**Subject:** M/68/20/PL- Poultry Farm 87 Yapton Road- Surface Water Drainage Comments

The application is a significant deviation from the previous scheme. Improvements to the drainage network are required. We will also require details of proposed site levels, with differences to existing levels clearly shown.

1. DRAWING PREPARED FOR THE SURFACE WATER DRAINAGE STRATEGY, NOT FOR CONSTRUCTION.
2. ALL LEVELS INDICATED ARE TO OS DATUM (METRES) FROM PROPOSED LEVELS RECEIVED.

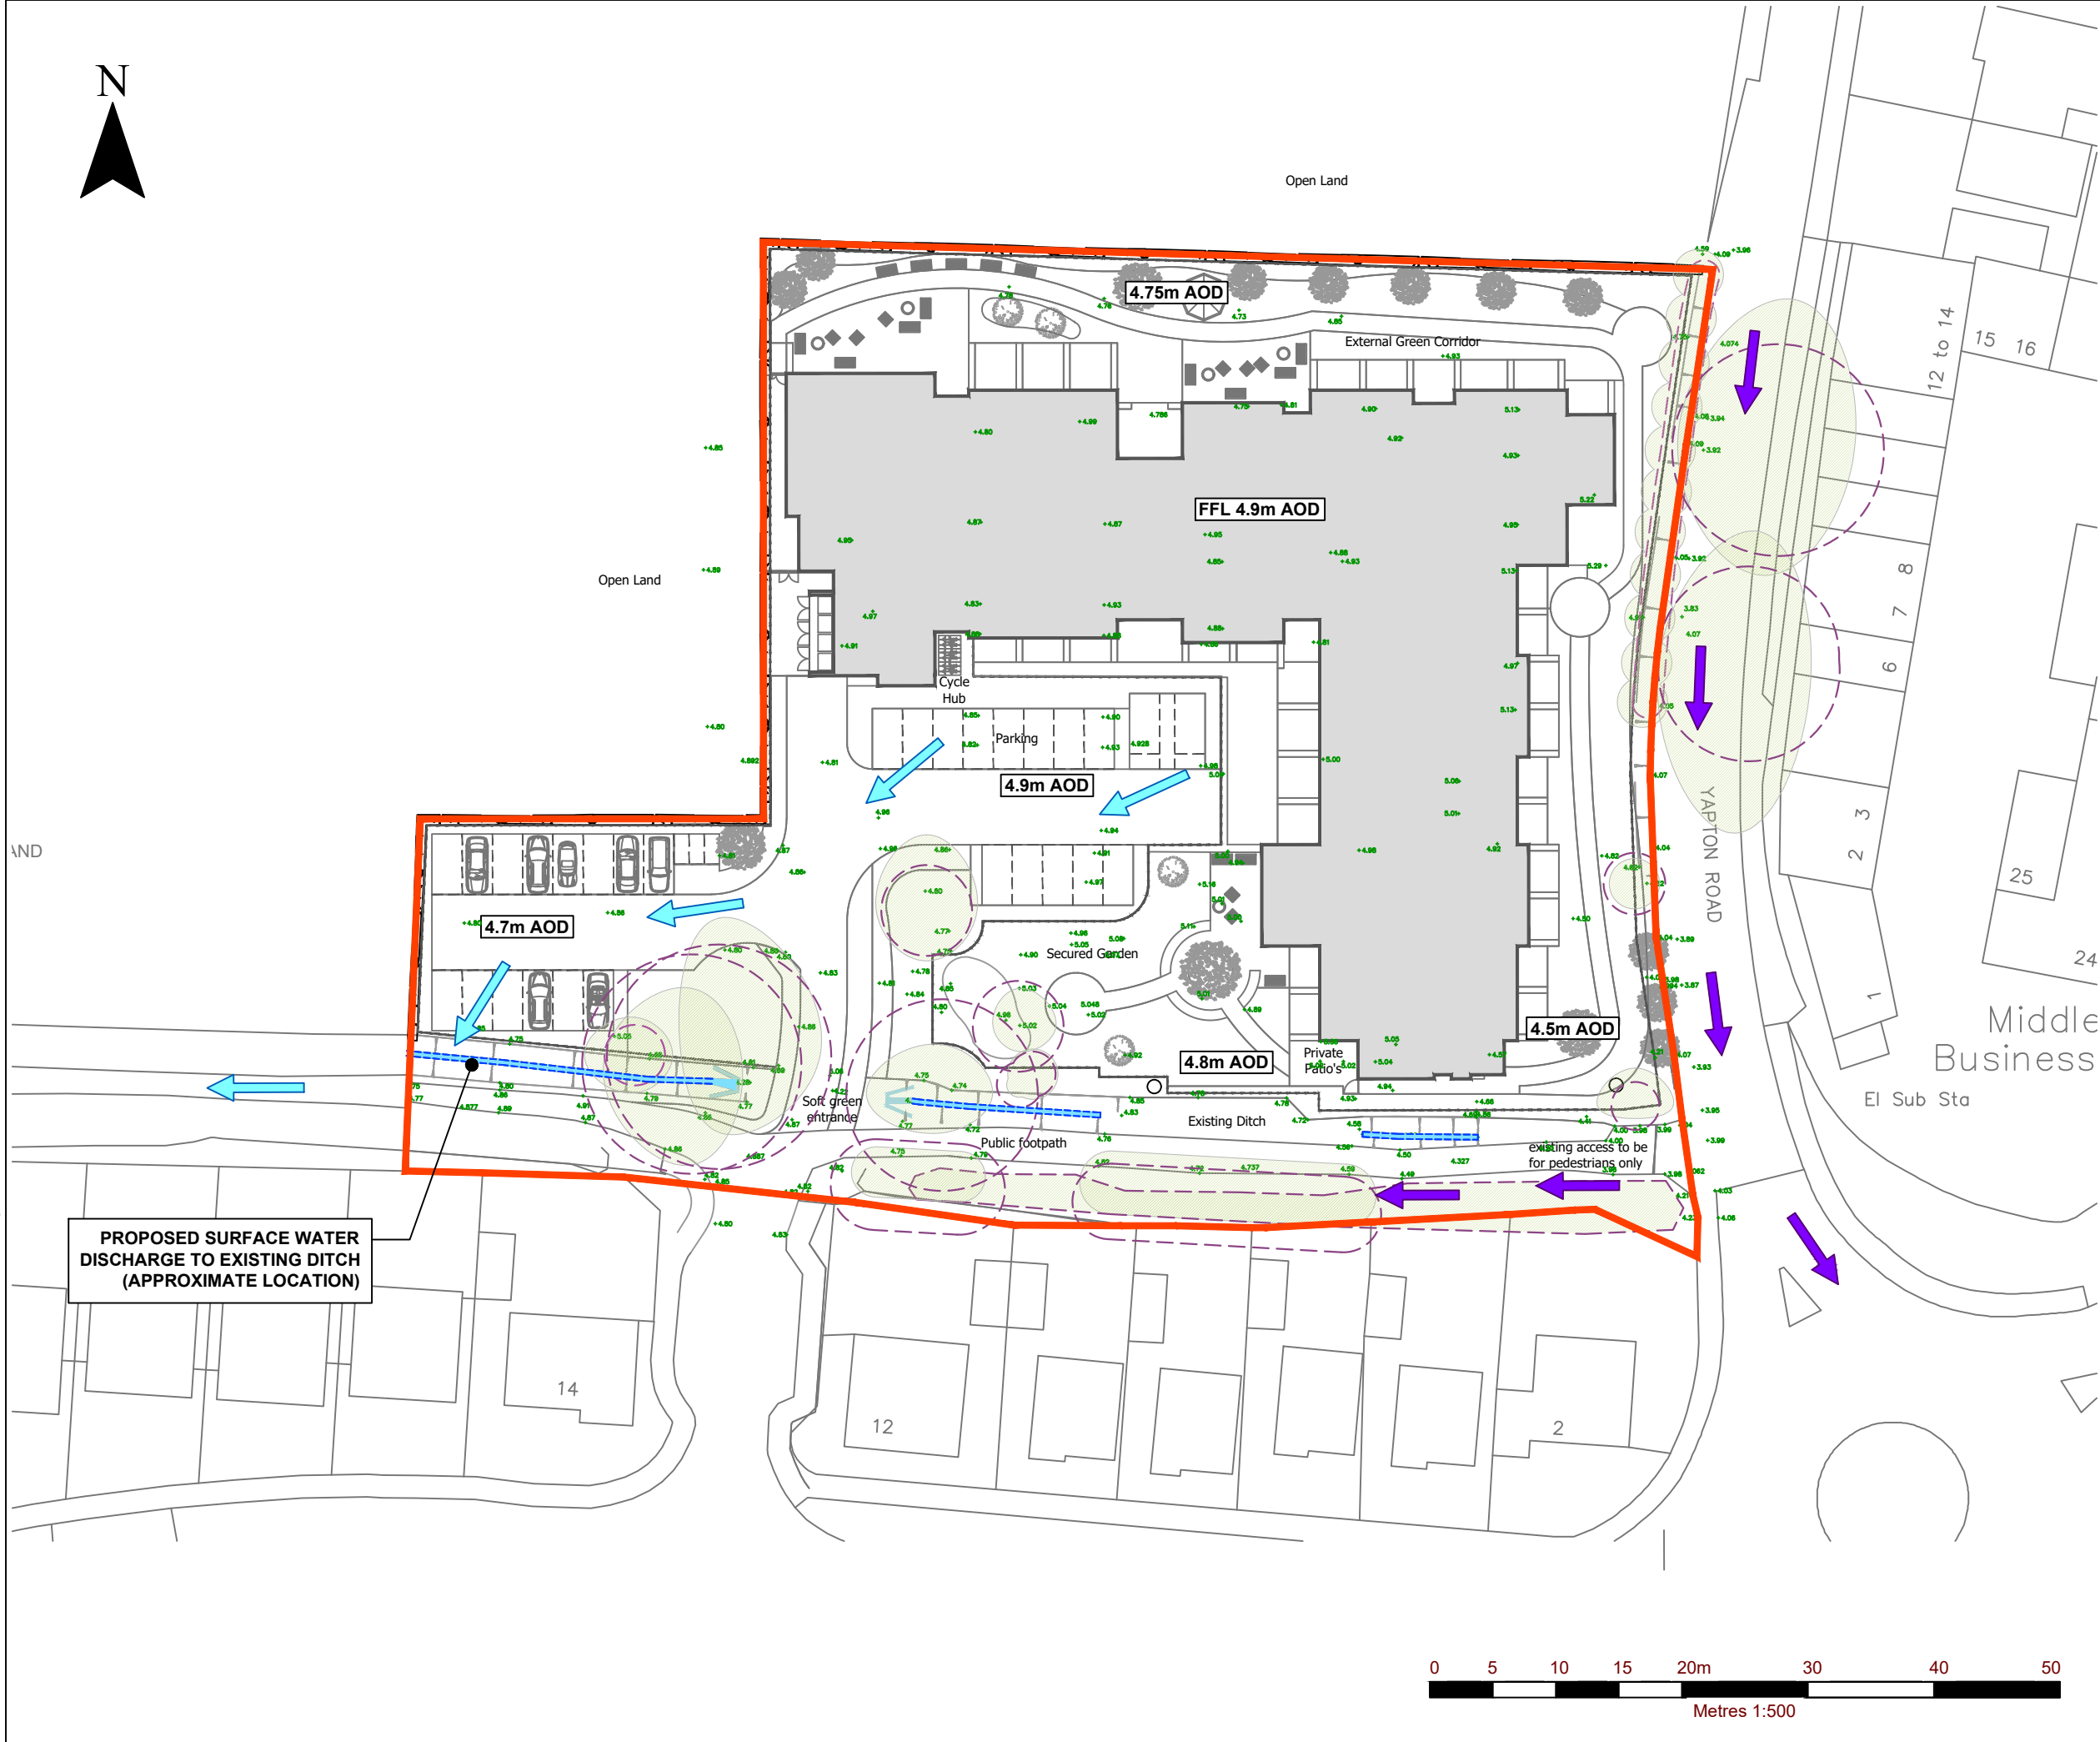
Proposed crates must be kept at least 3m from top of bank of ordinary watercourses. We have concerns regarding conflict between the draft drainage strategy and trees. On this basis we wish to place a **holding objection** on this application. It has not been demonstrated that there is adequate space within the proposed layout for surface water drainage. It is essential to establish if there is adequate space for surface water drainage prior to agreement of site layout. Drainage should be a fundamental consideration in design. Failure to secure a robustly evidenced implementable drainage strategy at this stage will likely unduly prejudice the drainage design and result in proposals failing to meet policy requirements.

A drawing that clearly shows trees that are to be retained, the root potential areas and the proposed drainage.
